25 September 2025

Our Ref: R/2025/4/D
File No: 2025/553139
Your Ref: SSD-79316759

**Advice on Amendment Report – Concept Proposal for mixed-use with time limited
Affordable Housing – 45-53 Macleay Street, Potts Point – SSD-79316759**

1 ELEVATION_SOUTH
1 : 200

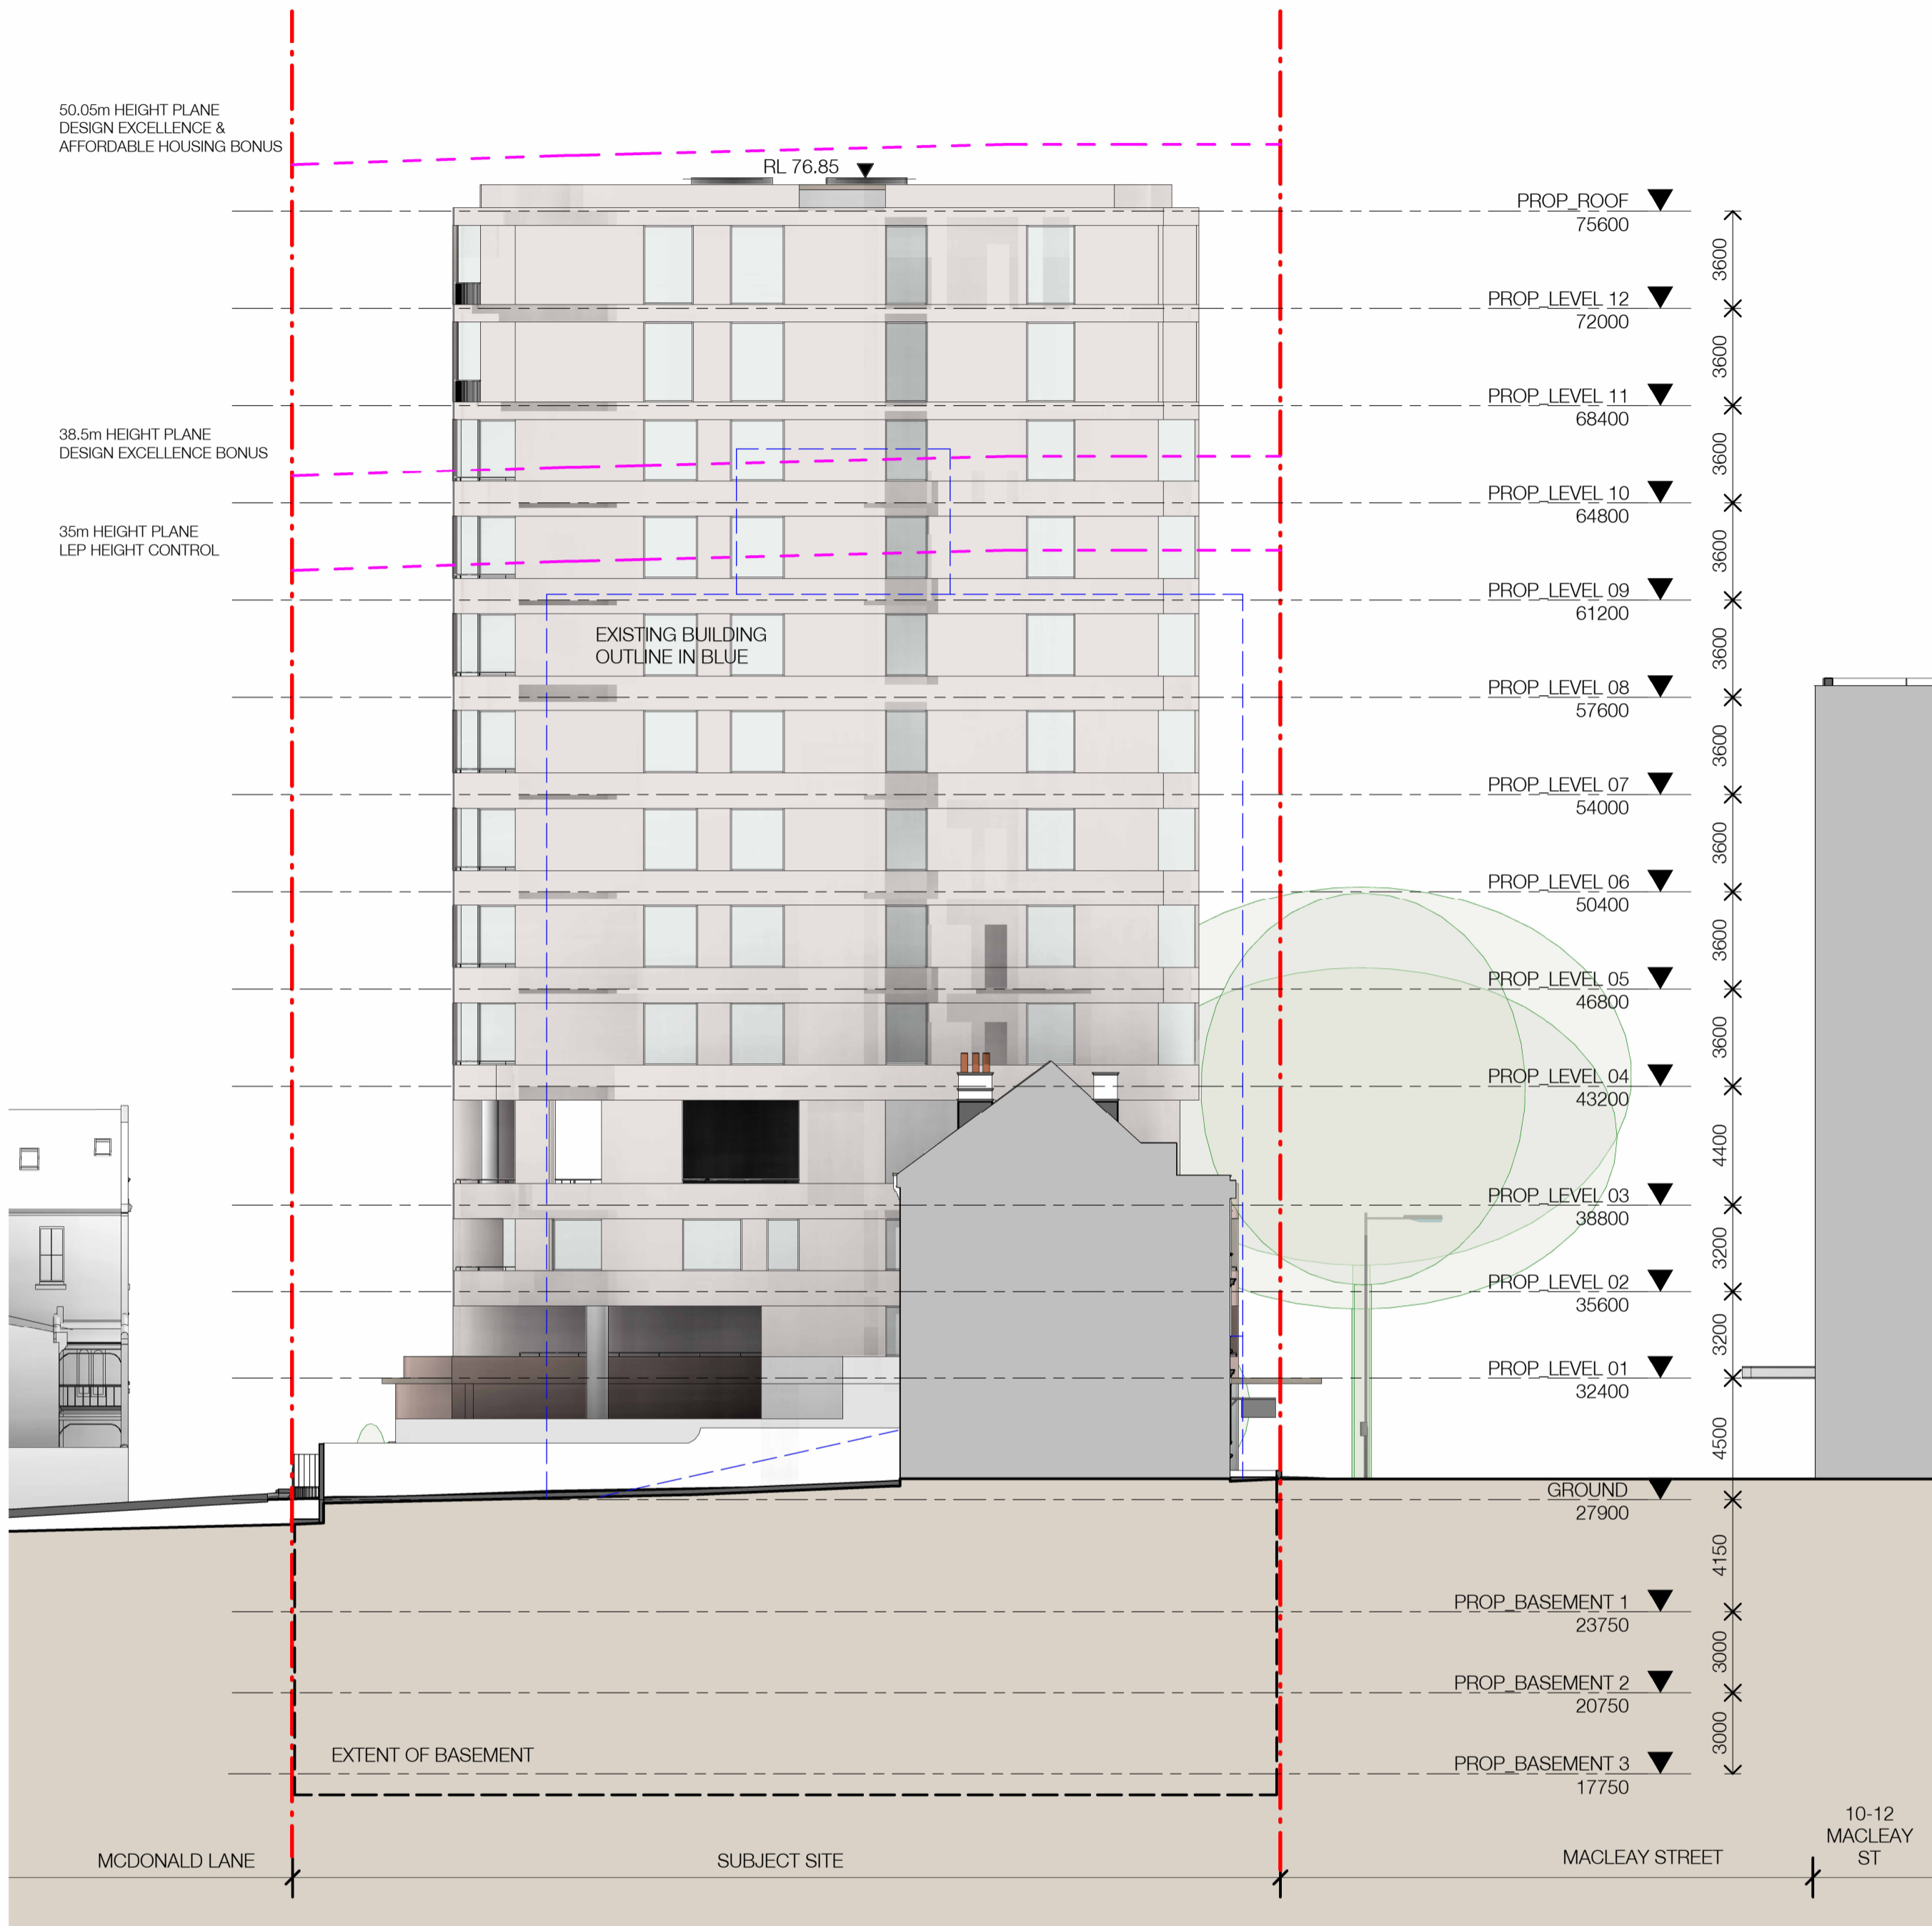
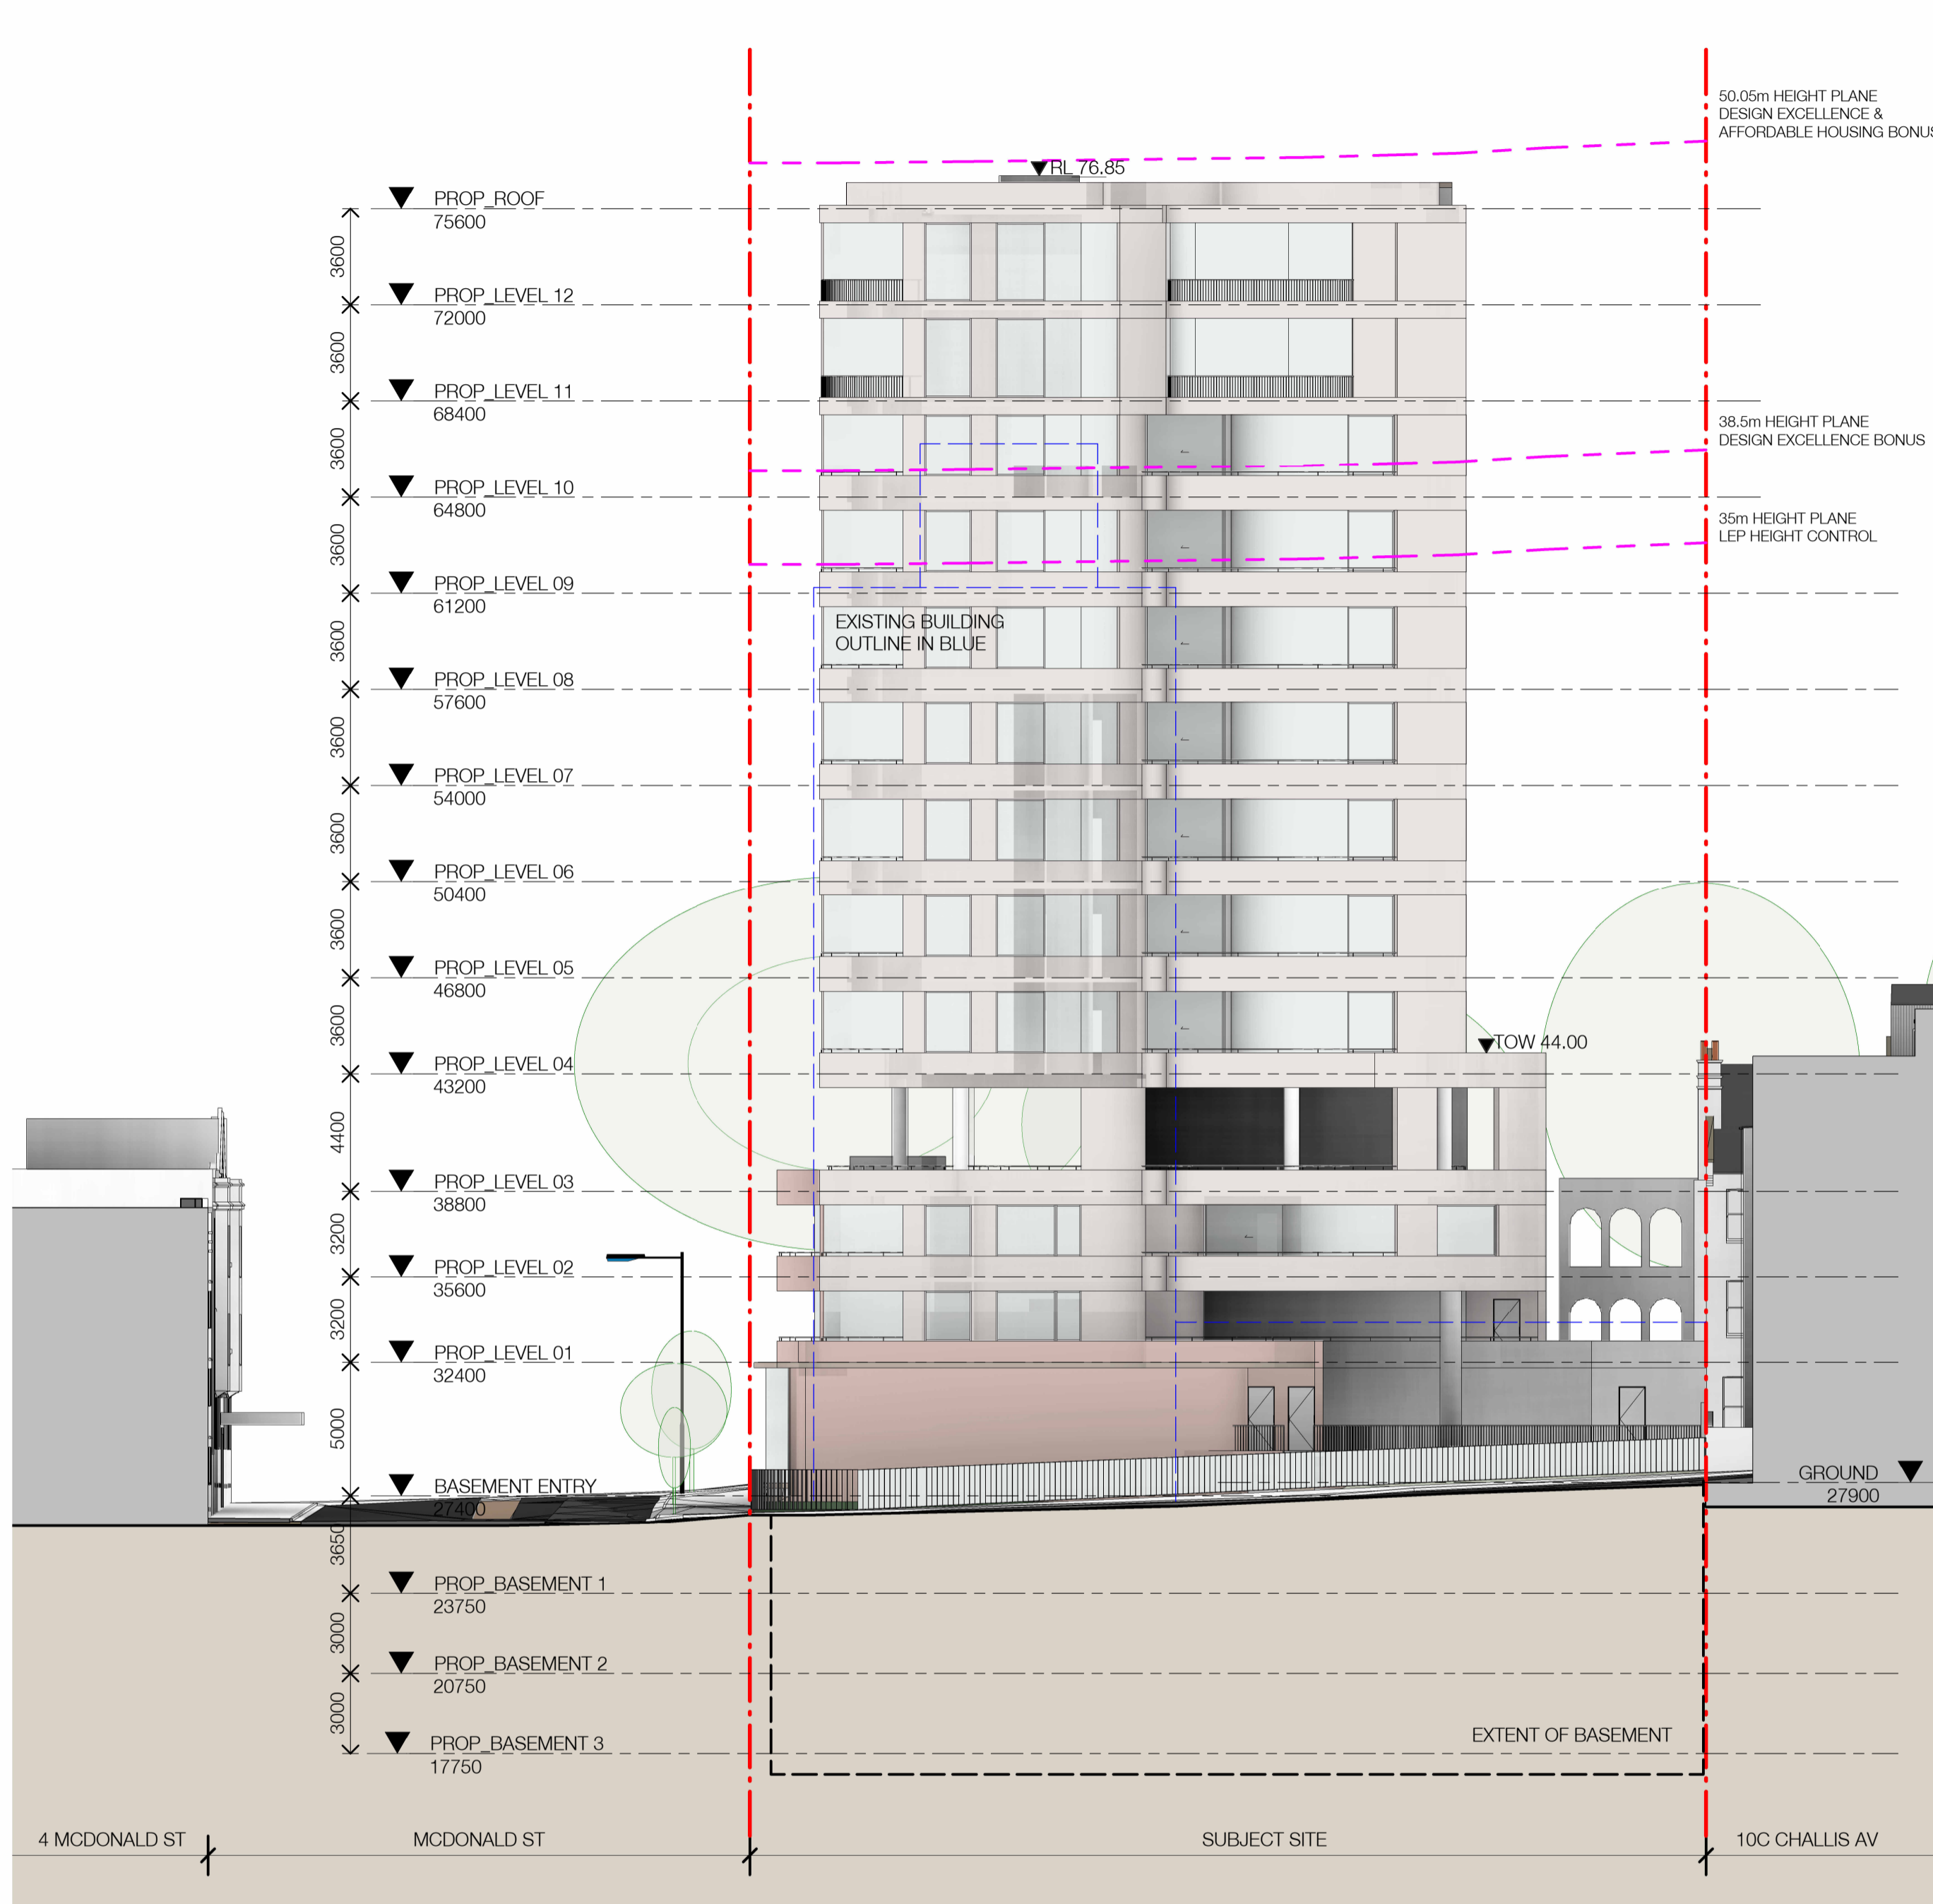
The Amendment Report states that the Stage 1 demolition works only includes demolition of the existing building to the ground floor slab, with no ground disturbance. However, the Demolition Work Plan in Appendix C includes demolition of slab on ground and foundations in section 5. The demolition elevation prepared by SJB does not provide any clarification.

The scope of demolition must be clarified, and all documents must be amended to ensure consistency.

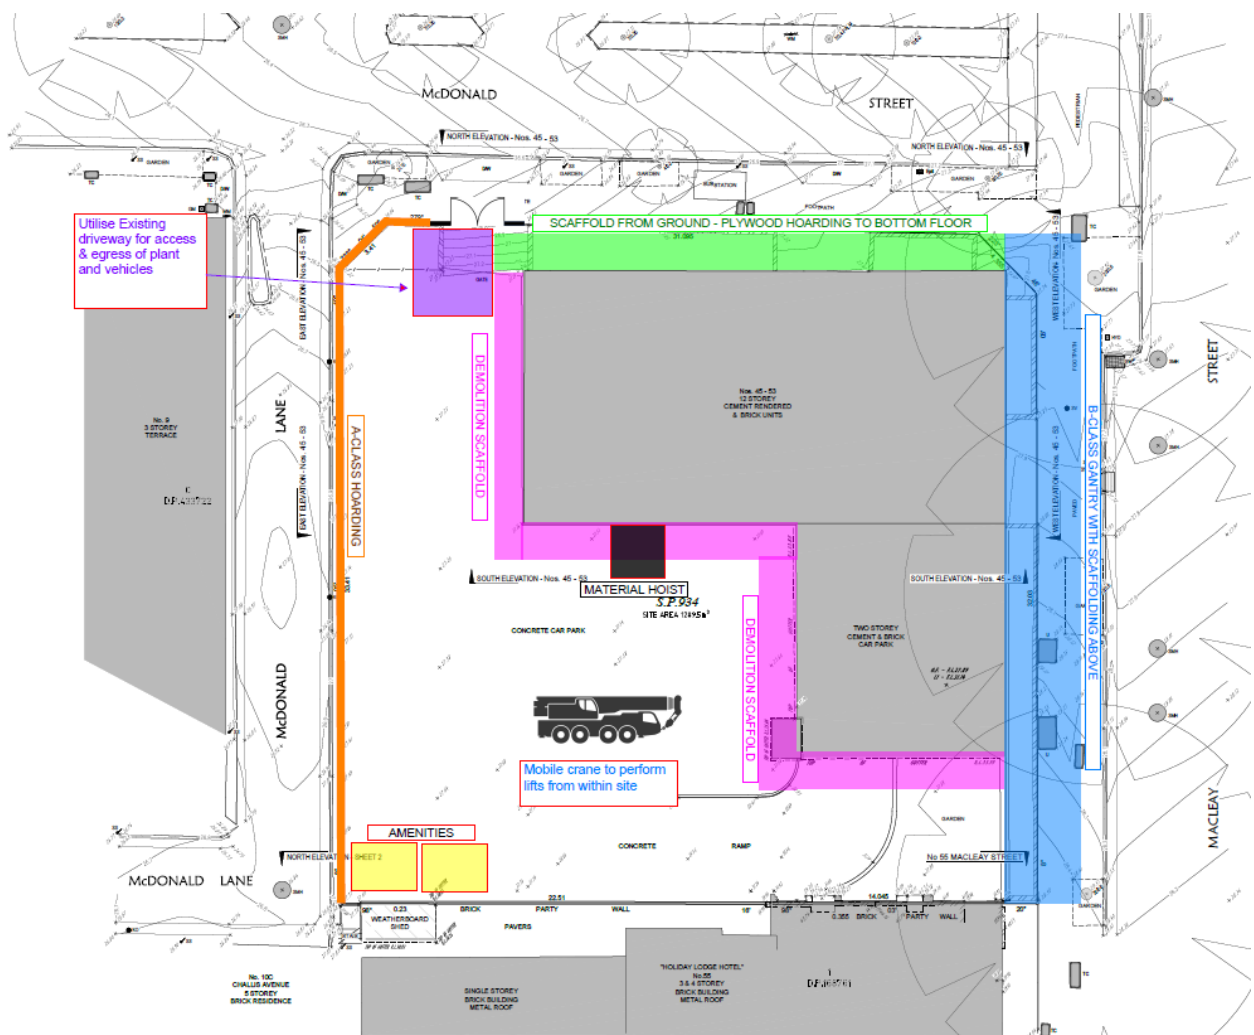
Section 1.0 of the Demolition Work Plan also identifies the removal of trees, shrubs and soil on Macleay Street and McDonald Street to enable the erection of B-class hoarding

and scaffolding. However, the Tree Protection Specifications and Plan (TPSP) in Appendix H identifies all trees to be retained.

The TSPS and the Demolition Work Plan need to be updated to provide consistent information. No removal of any trees, shrubs or soil within the public domain will be permitted.
